014/5039/DJ/SRJ

Royd Edge Mill, Meltham – Local Authority Land Contamination Technical Comments Response

Further to the planning consultation response email dated 3rd October 2024, relating to discharge of Conditions 7 & 8, we are writing to address comments made by Kirklees Council on your behalf.

**Figure 3 Plan of Areas of Soil Remediated**

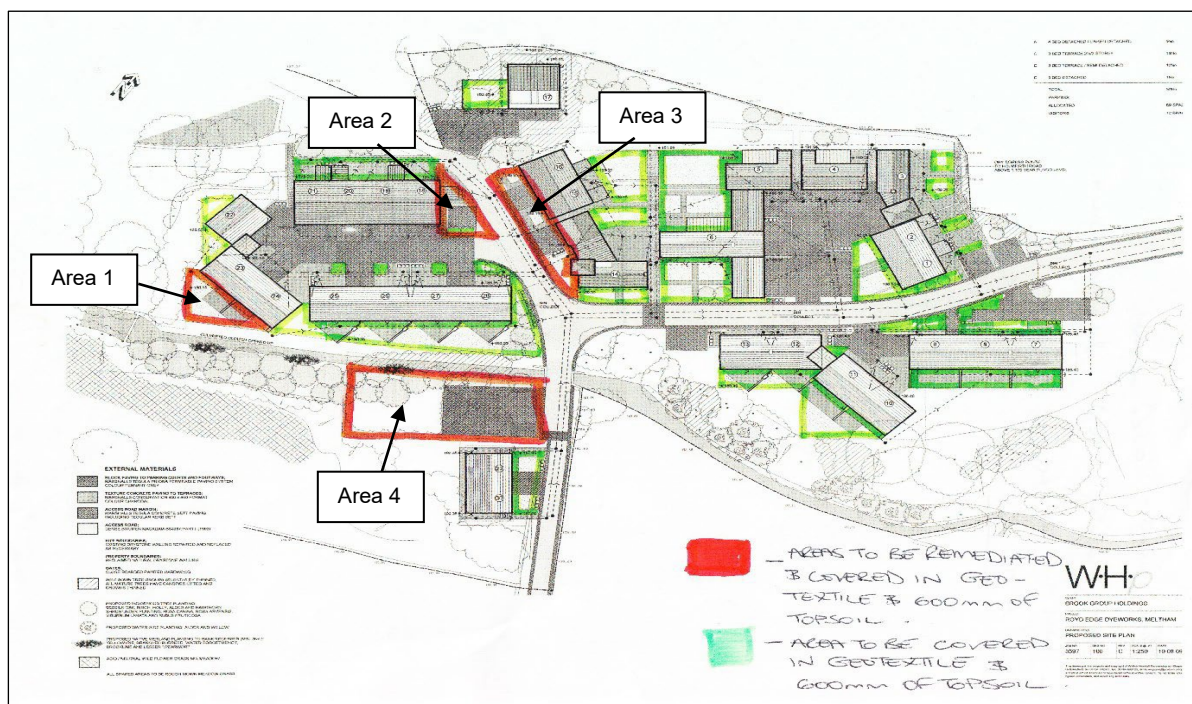
- 2) The revised report must ensure that naphthalene levels indicated in the WSG sample, along with a clear plan detailing the exact location of the WSG are included*

As per the Section 7.1 of the updated Interim Validation Report by Ashton Bennett borehole location WSG was within the previously (c.2011) remediated Area 4. This area was subject to excavation to 0.5m of the existing ground level at the time followed by disposal of arisings to landfill. The area was rechecked for signs of contamination by Ashton Bennett. Further to this the garden areas of these plots (and all plots on site where made ground is still present at the surface). These plots will therefore be covered with a 600mm clean cover system comprising 300mm virgin quarried stone and 300mm topsoil with a geotextile high visibility marker layer at the base. Lithos are in the process of validating these cover systems in terms of depths and also assessing the quality of soils (visually and chemical testing) and virgin quarried stone (visually checking quality) used within the cover system.

A plan of the approximate borehole positions overlaid with the proposed plot layout has been compiled by the developers consulting engineers (Dudleys) based on the Ashton Bennett plans and is appended to this letter.
